# **Awel y Môr Offshore Wind Farm Examination Review of SLVIA Documents**

**Final report**  
Prepared by LUC  
October 2022

### Awel y Môr Offshore Wind Farm Examination Review of SLVIA Documents

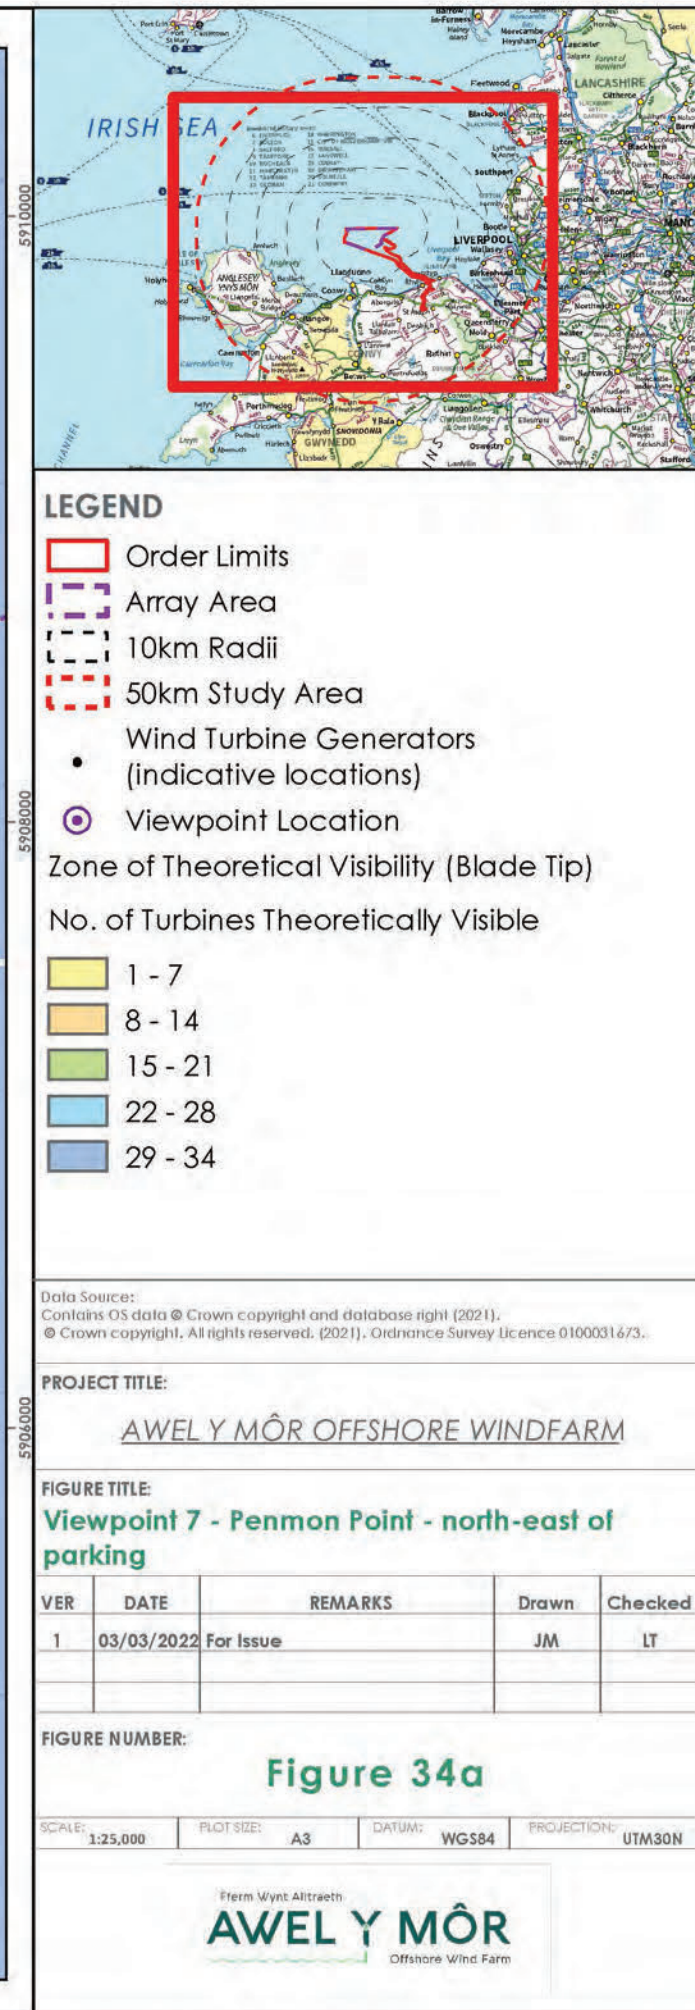
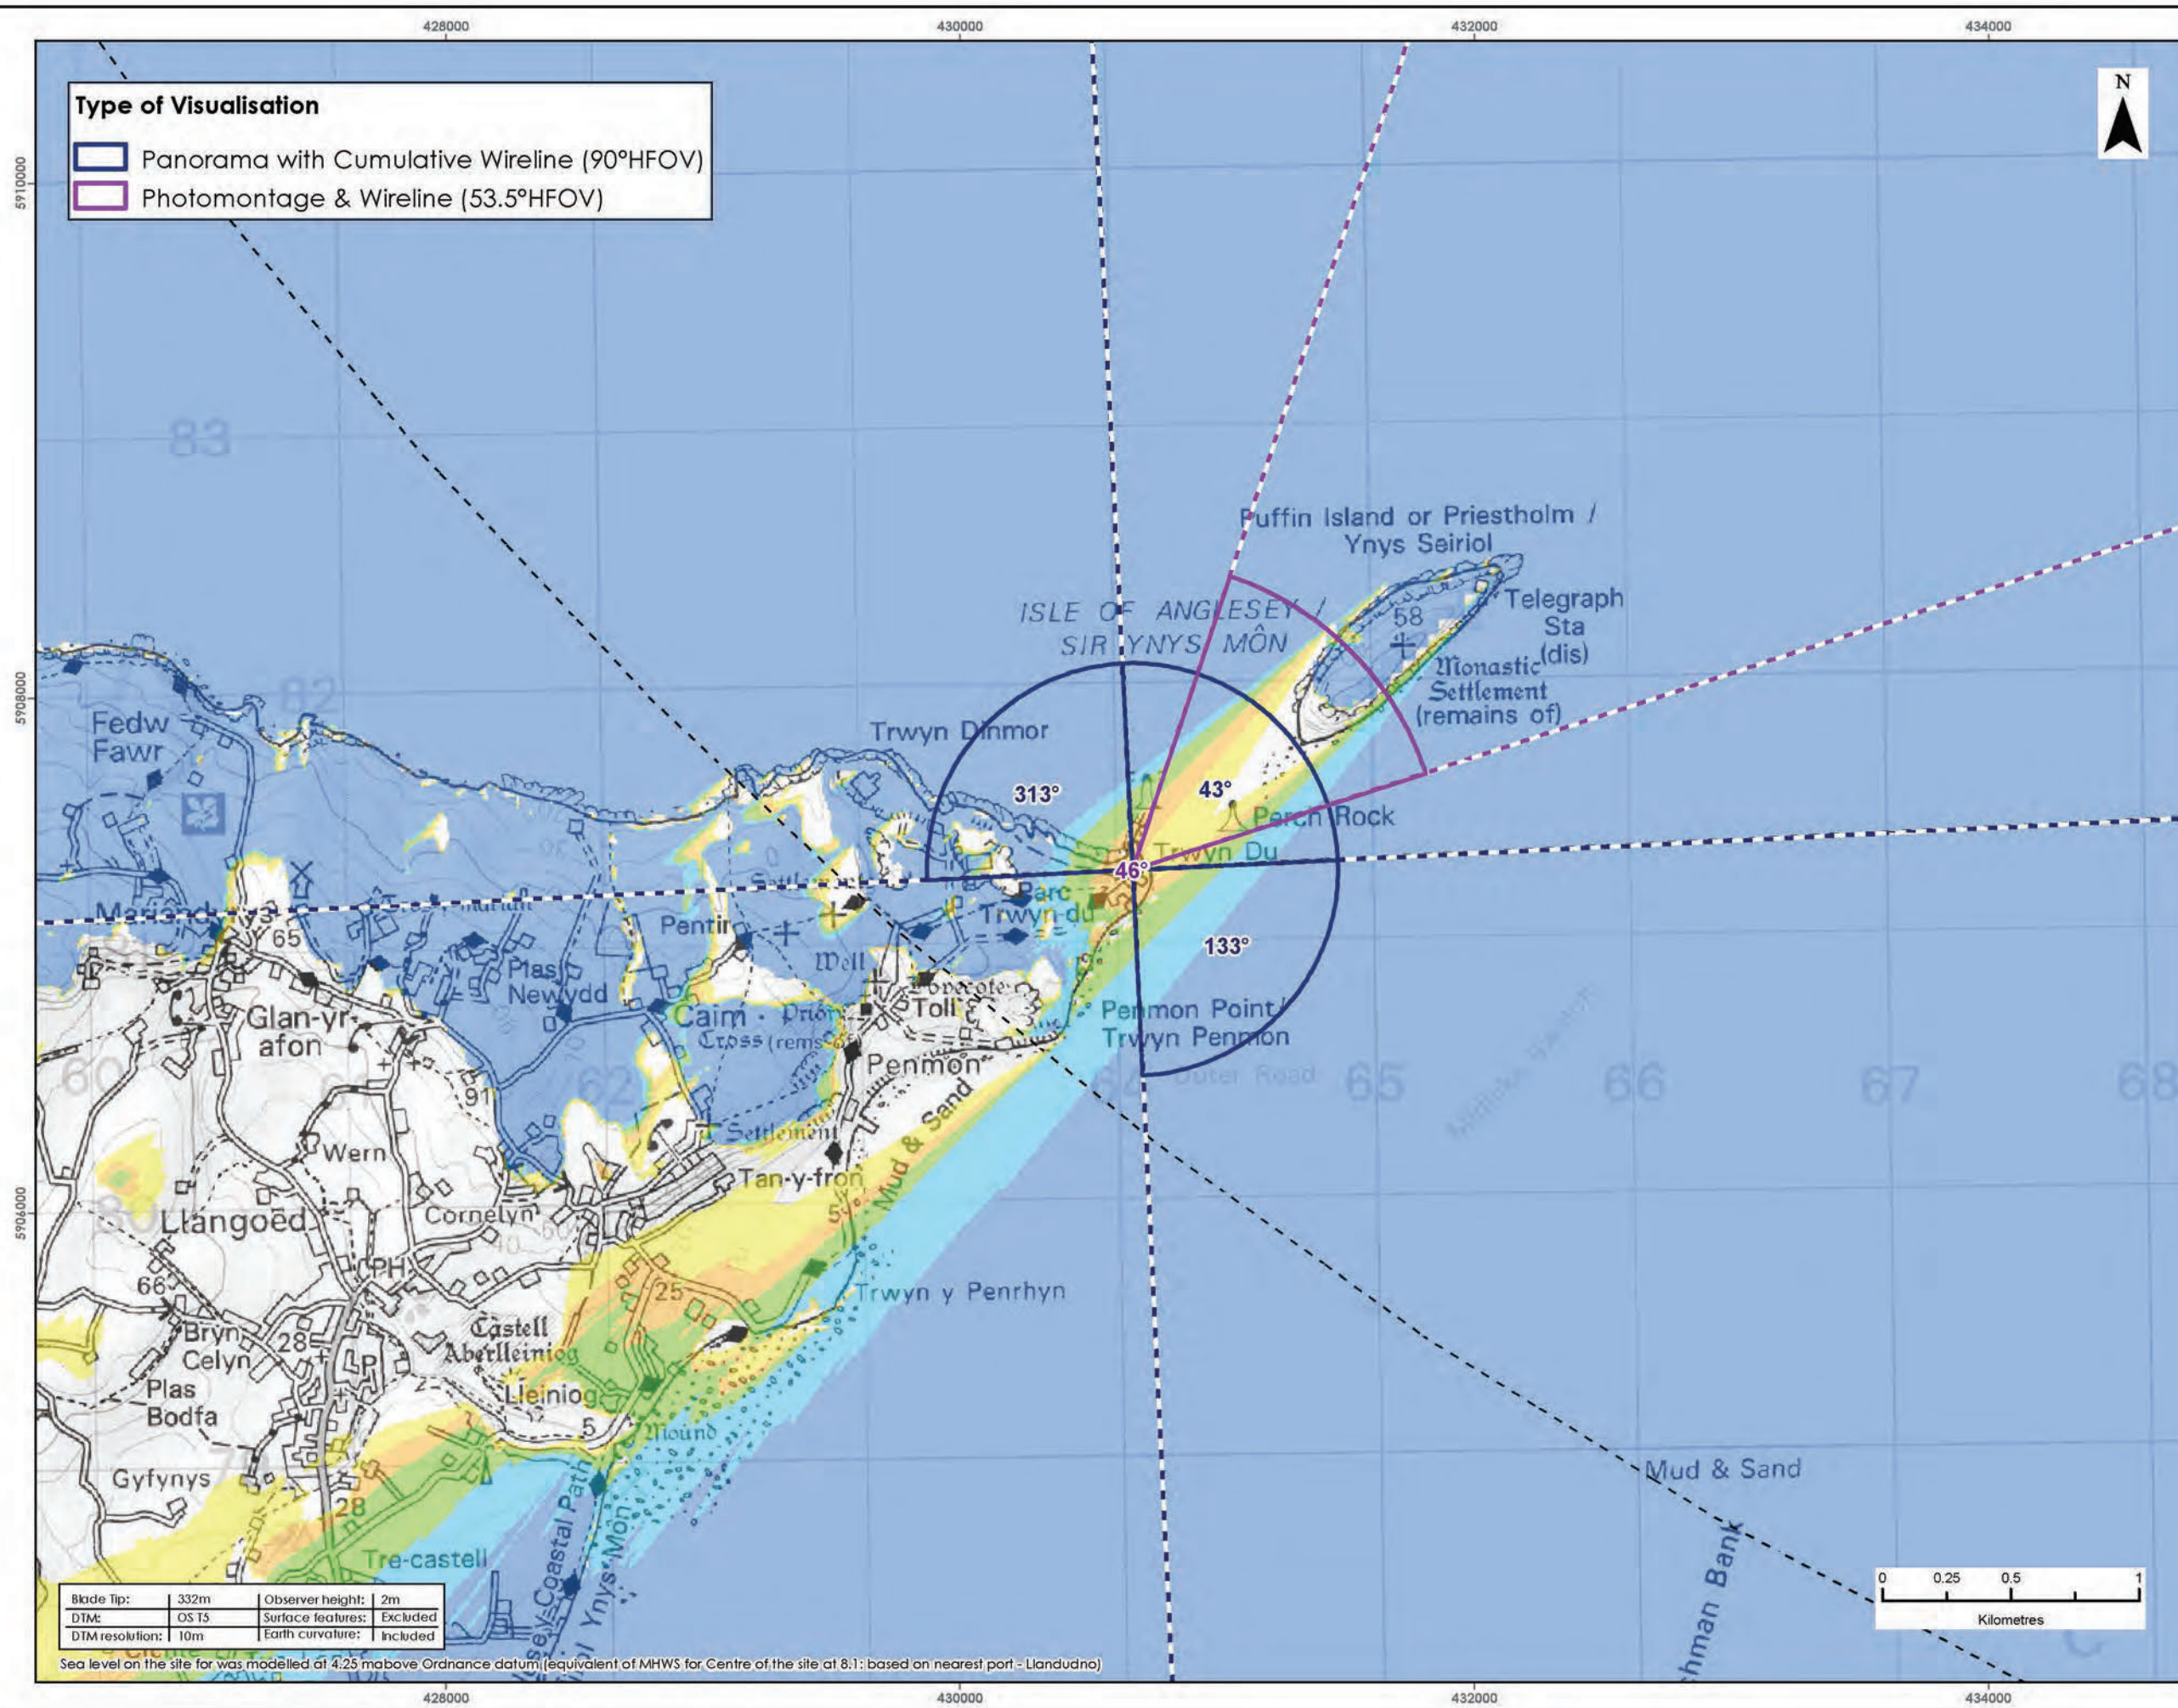
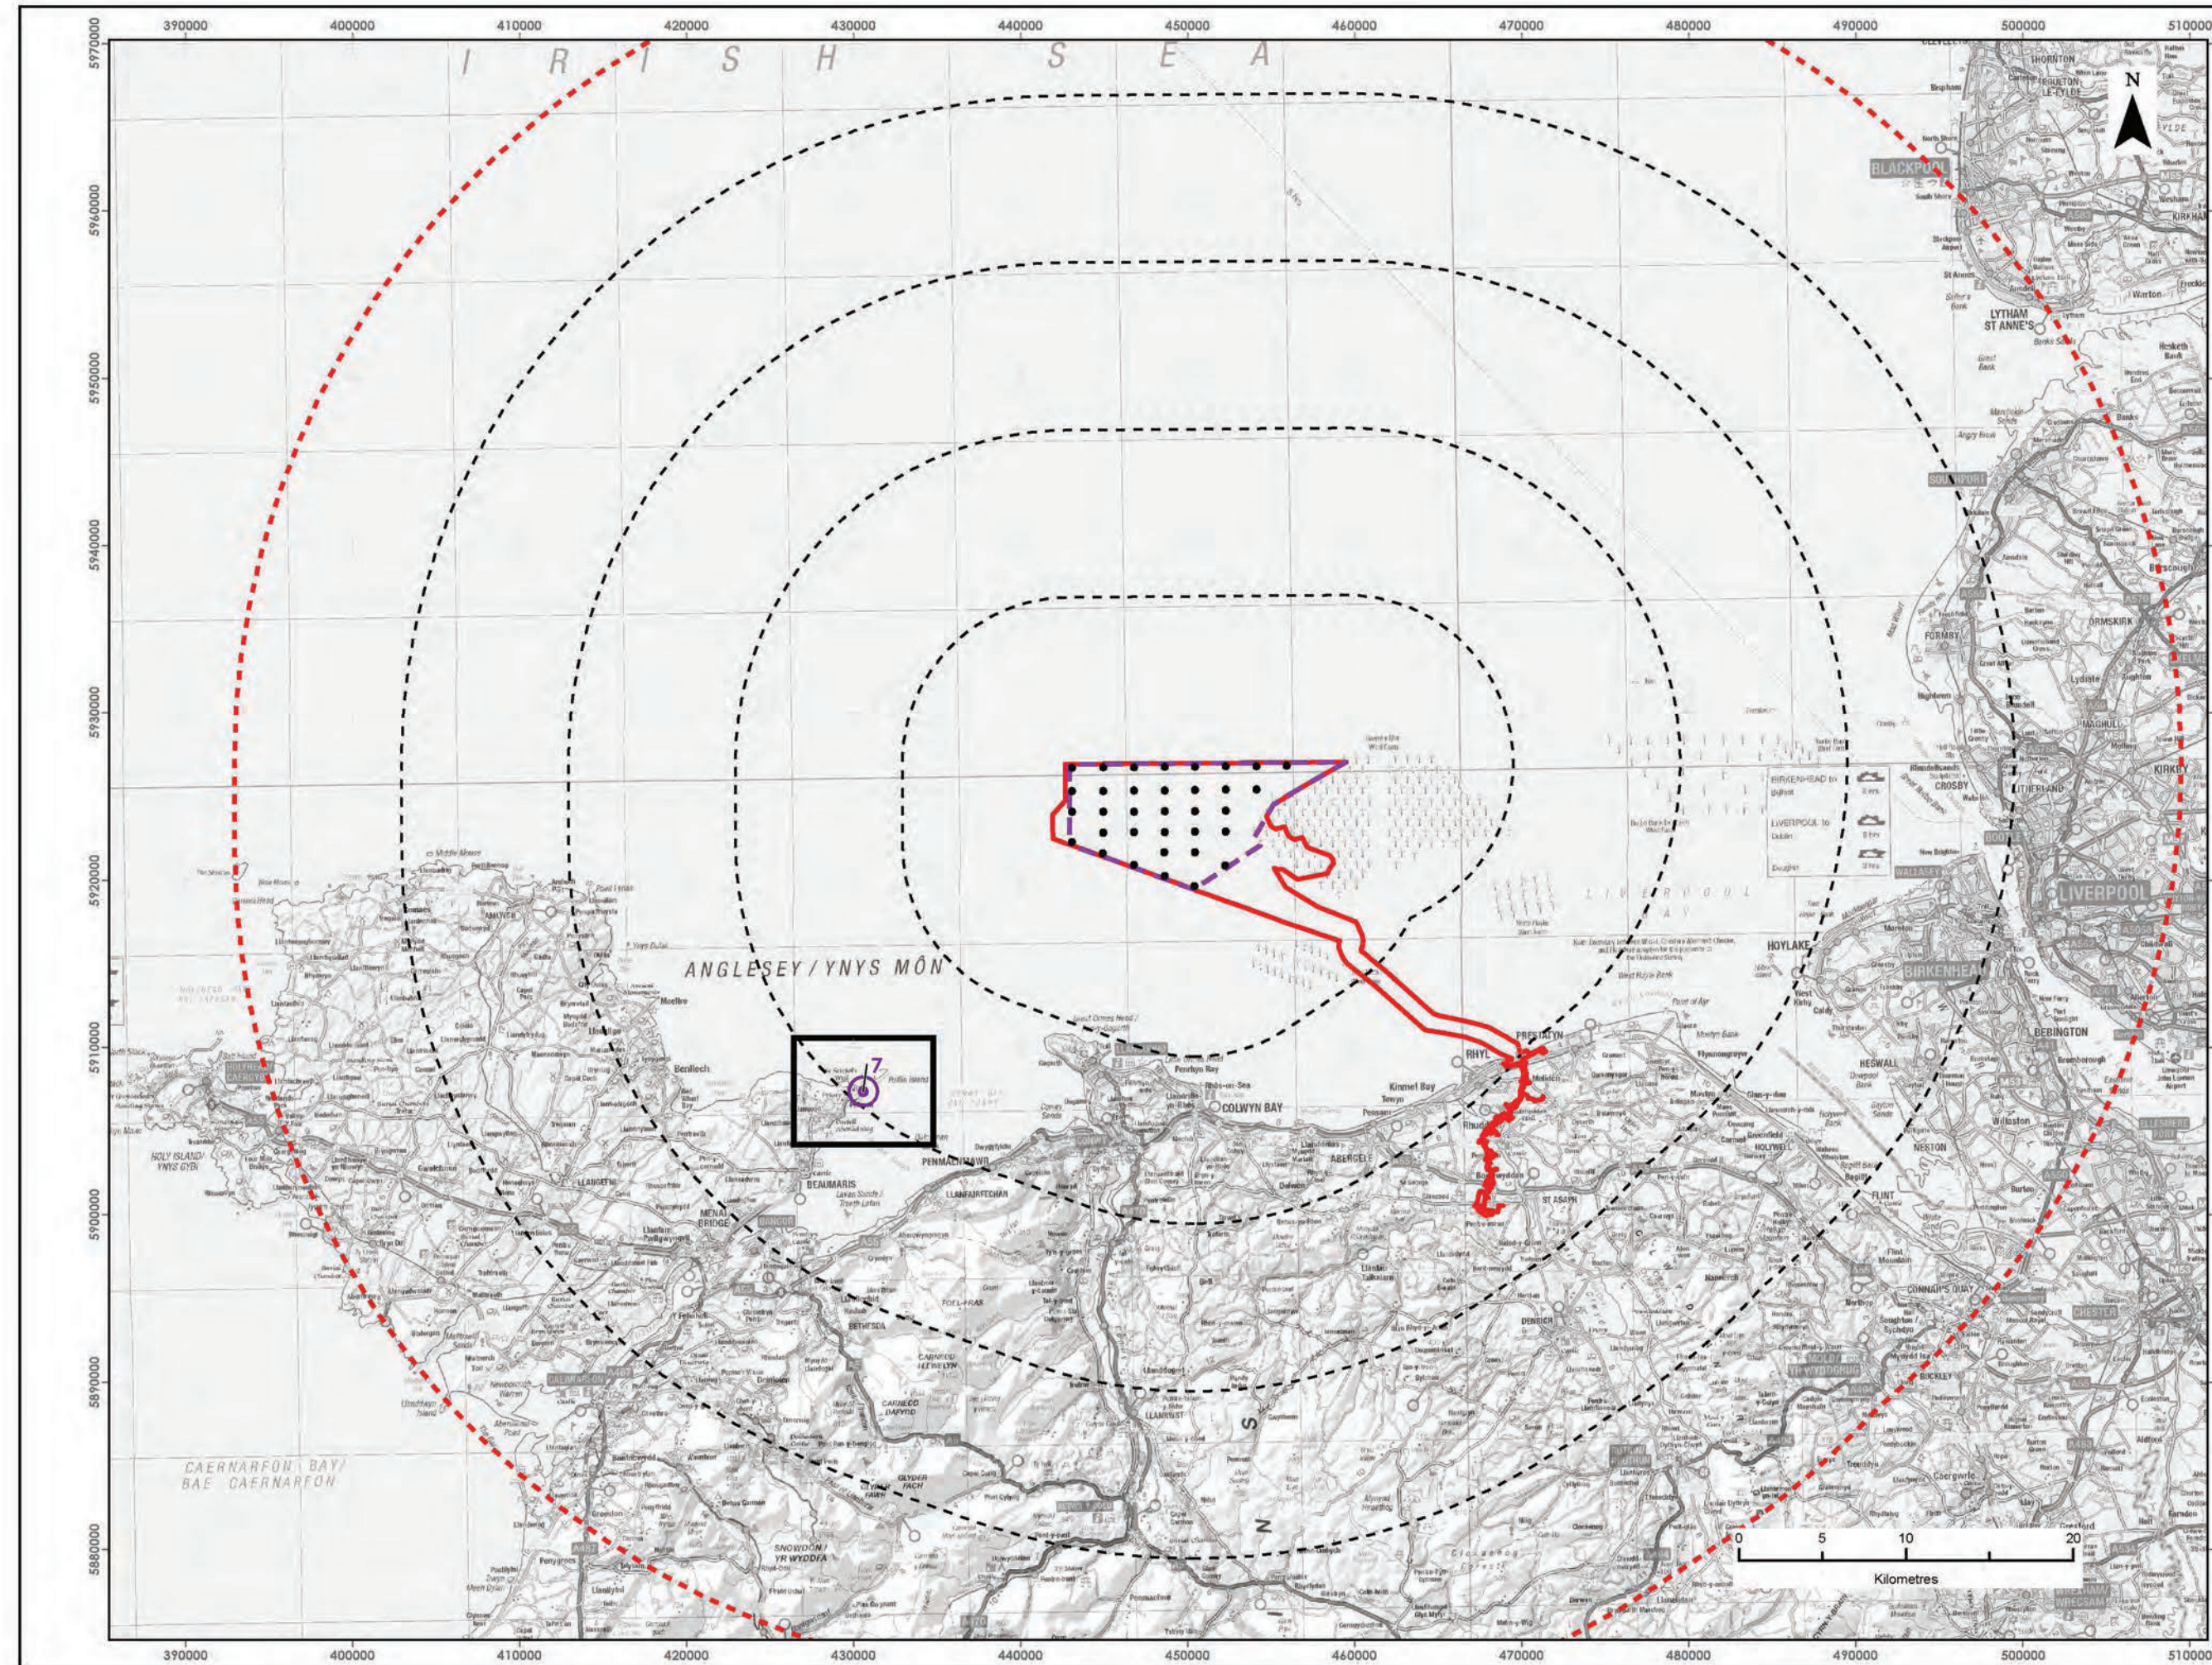
**3.9** There are 13 assessment viewpoints on Anglesey, and the SLVIA finds significant effects at eight of these locations. This is the same result as in the PEIR. All the identified significant effects are 'moderate', with the exception of VP7 Penmon Point and VP8 Beaumaris, which are 'major-moderate'. These findings are agreed.
